**Consultation Response from KC,
Trees**

2024/91133 Various locations - A629, Halifax Road, Huddersfield

Discharge conditions 5 (car park/footway), 6 (tree pit and rootspace), 7 (boundary treatment), 11 (retaining wall), 15 (Preliminary Risk Assessments) on previous permission 2021/92734 for improvement and widening of the A629 to include junction improvements, re-positioning of footways and footway improvements, pedestrian crossing provision, the alteration, demolition and erection of walls, construction of retaining walls, erection of fencing, hard and soft landscaping to include the removal of trees and replacement planting, replacement street lighting, change of use of land to highway and change of use to and formation of car park on land adjoining 103 Halifax Road (within a Conservation Area)

Date Responded: 19/06/2024

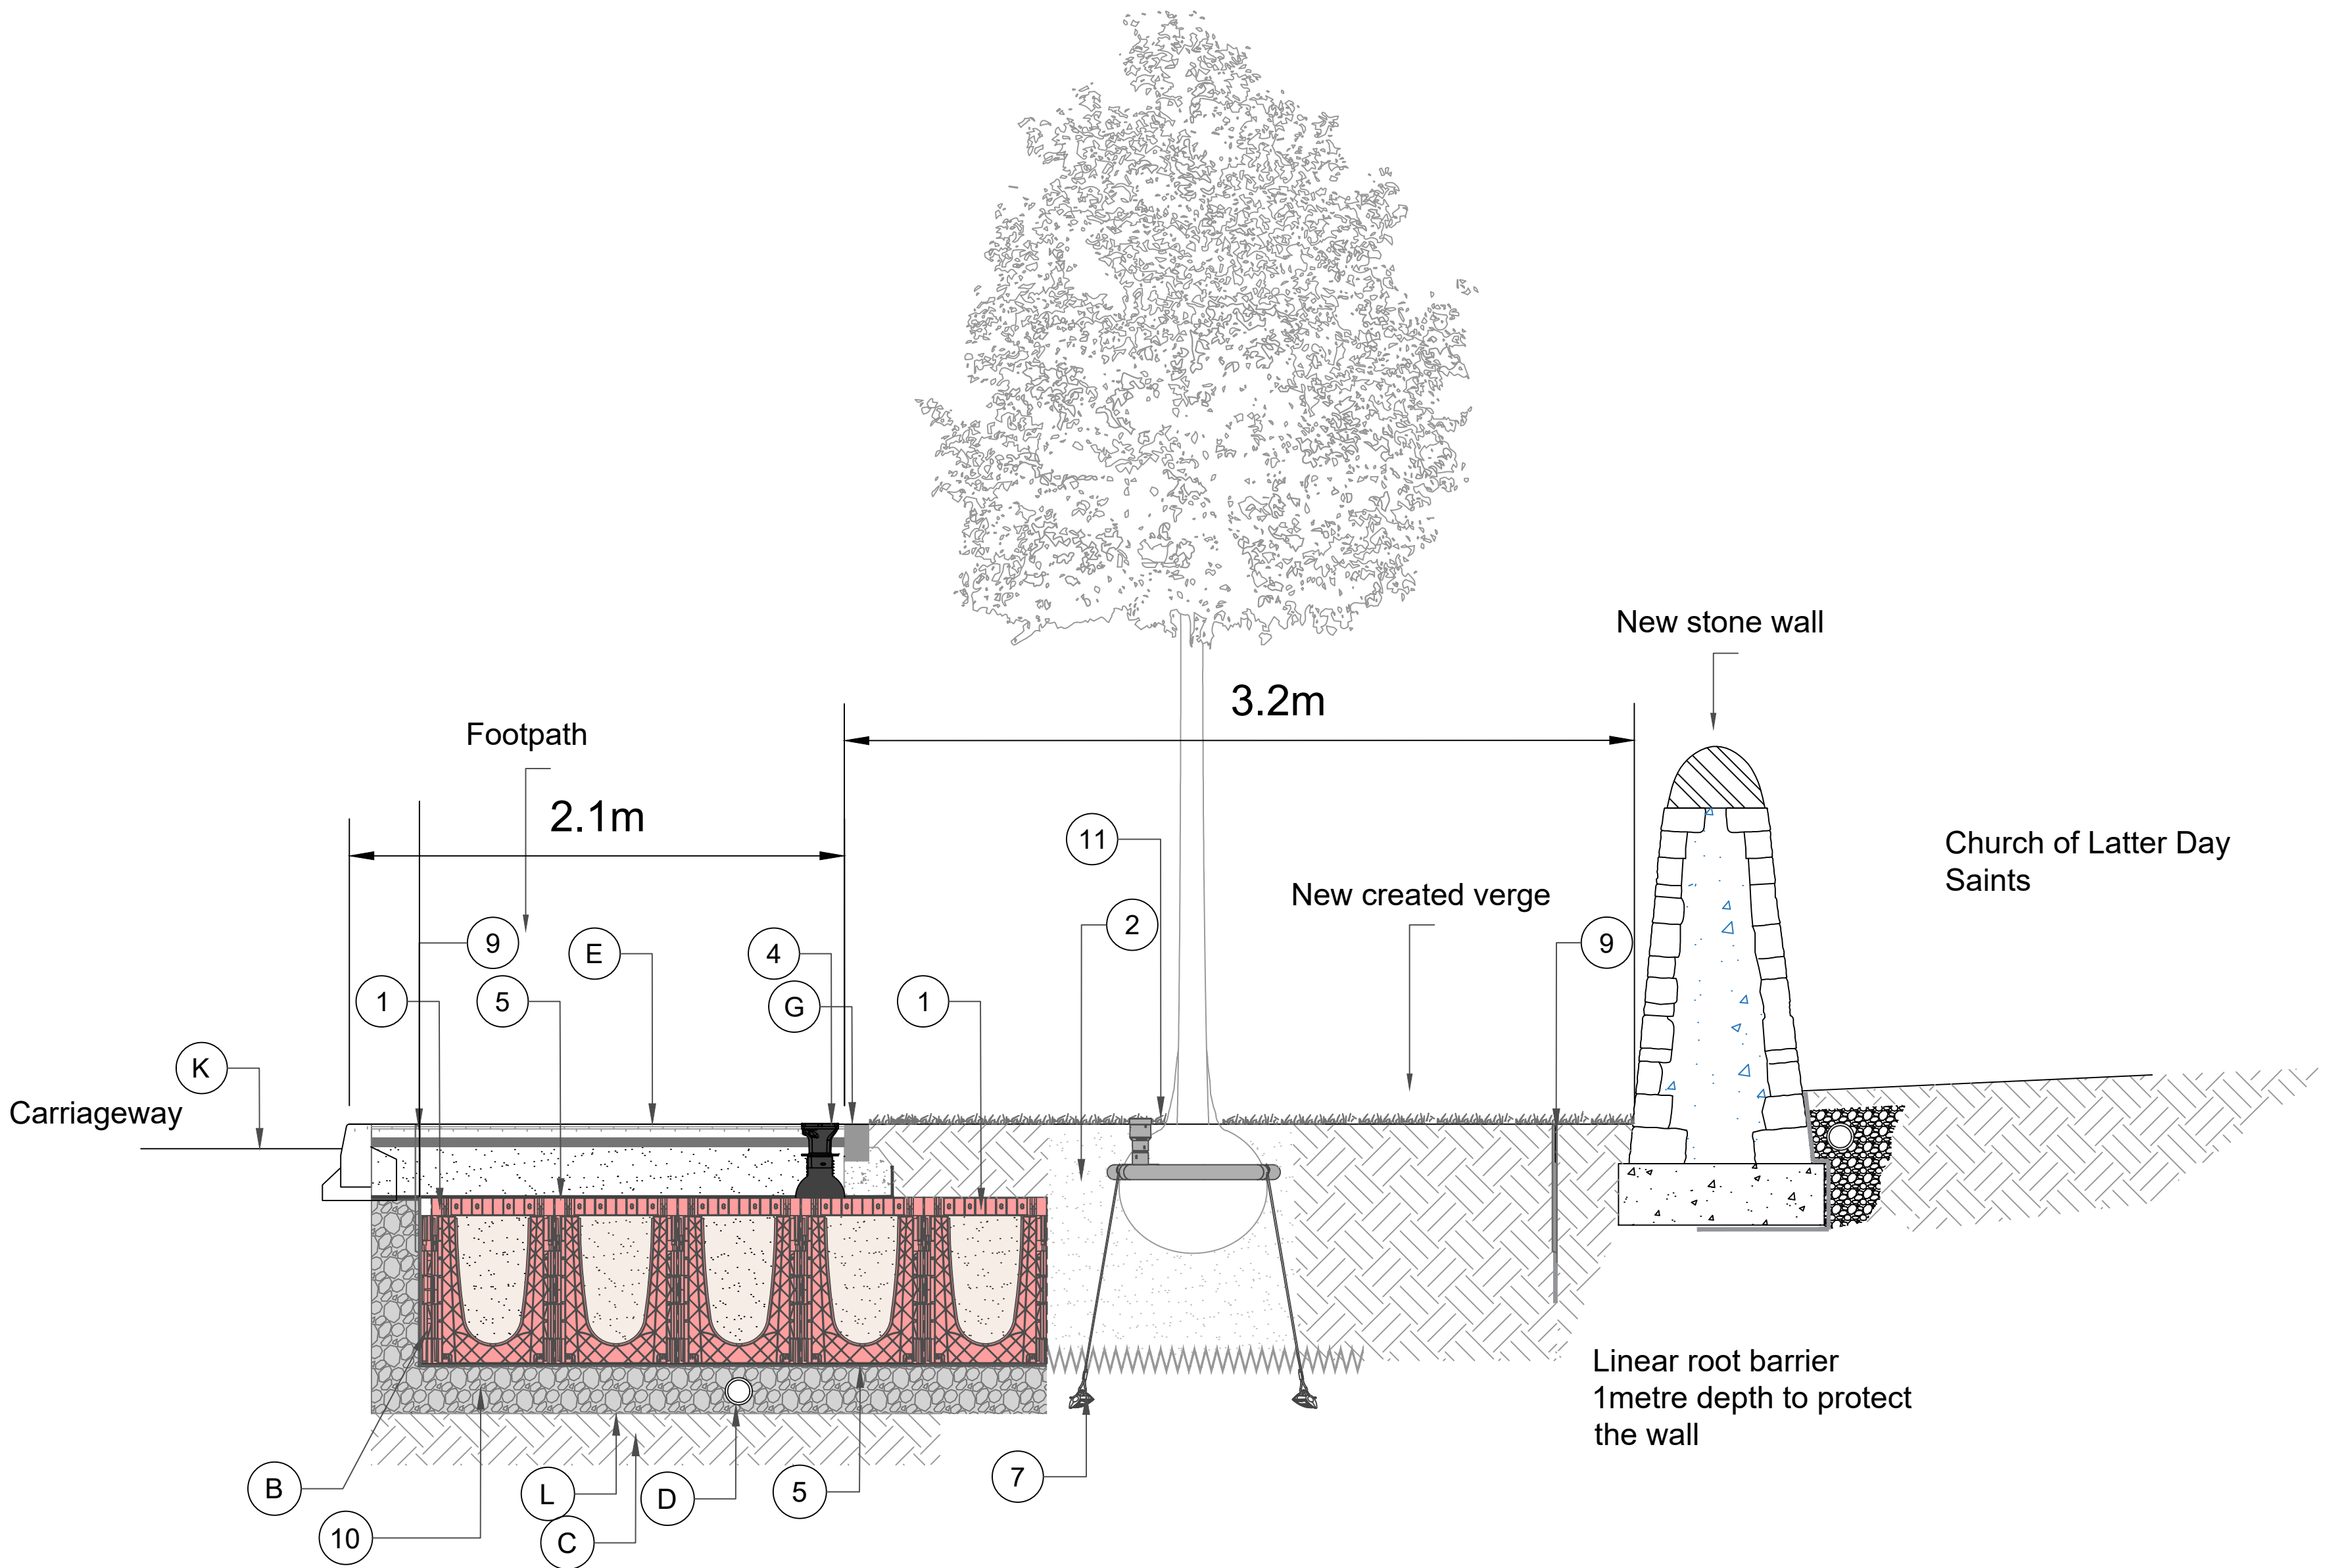
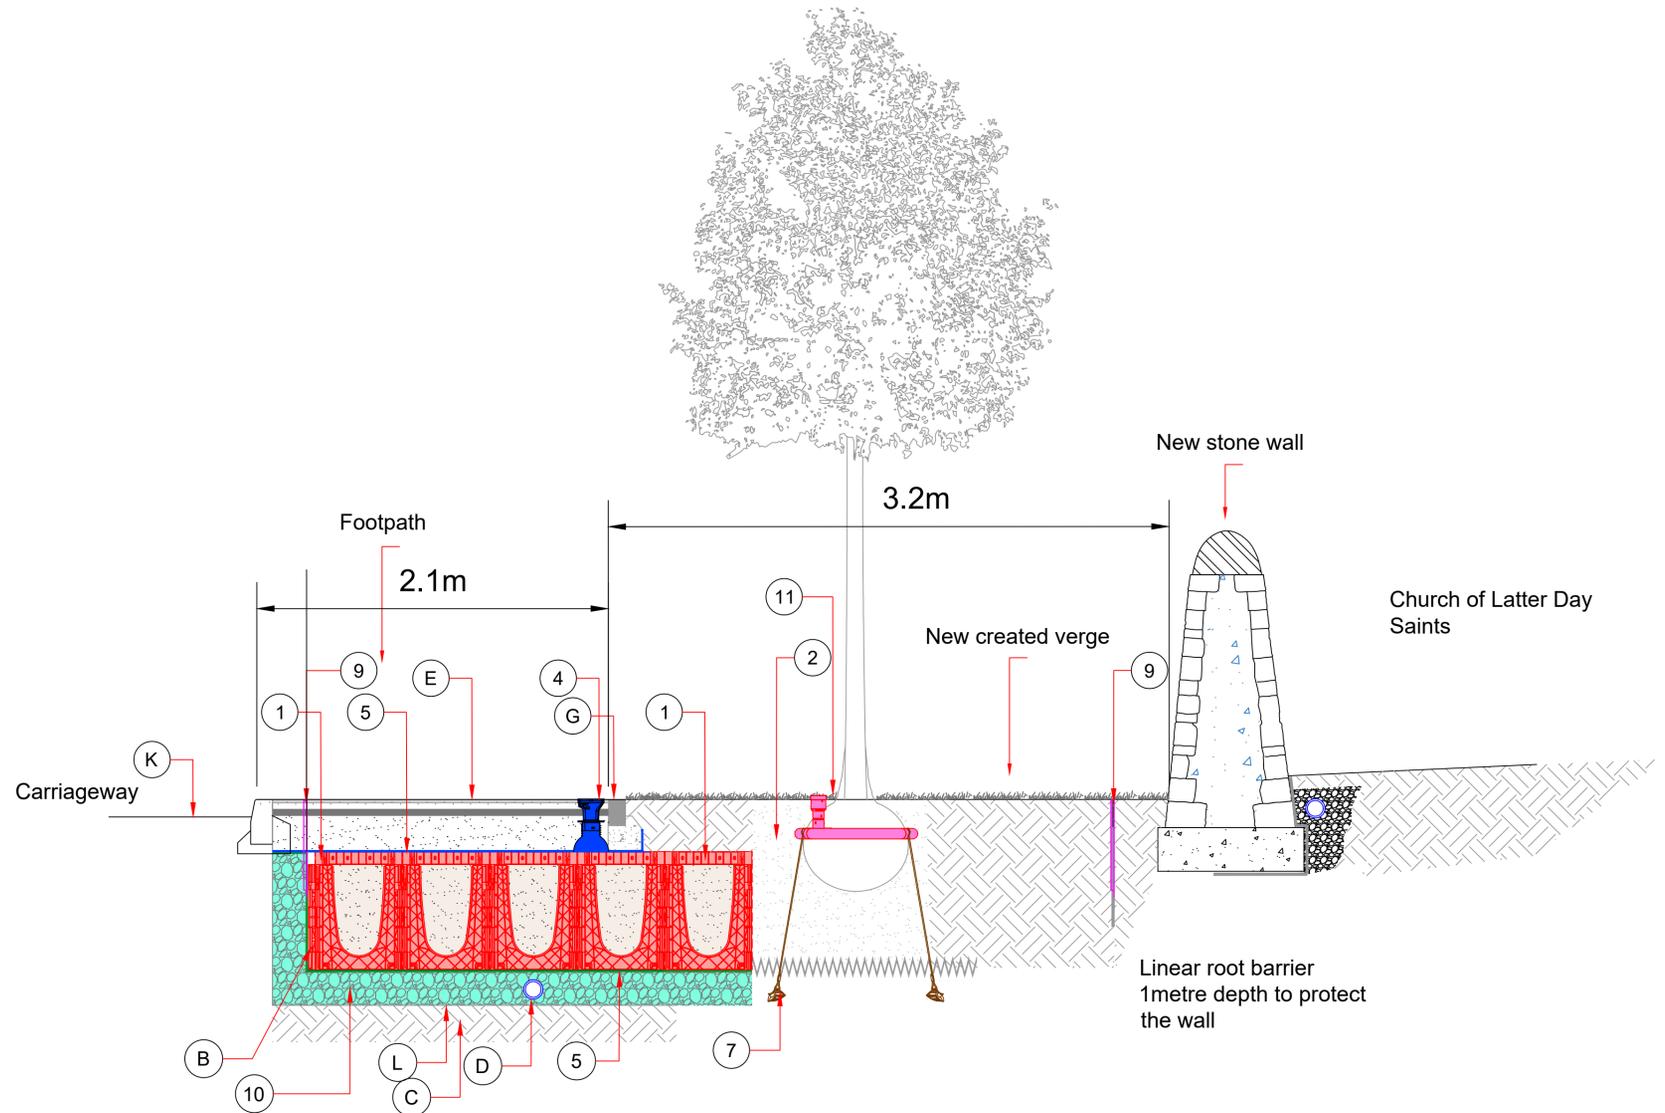
The revised plans are sufficient in detailing the proposed new planting at site C and tree pits to be used at site B. KC Trees is happy to release the conditions 5 and 6.
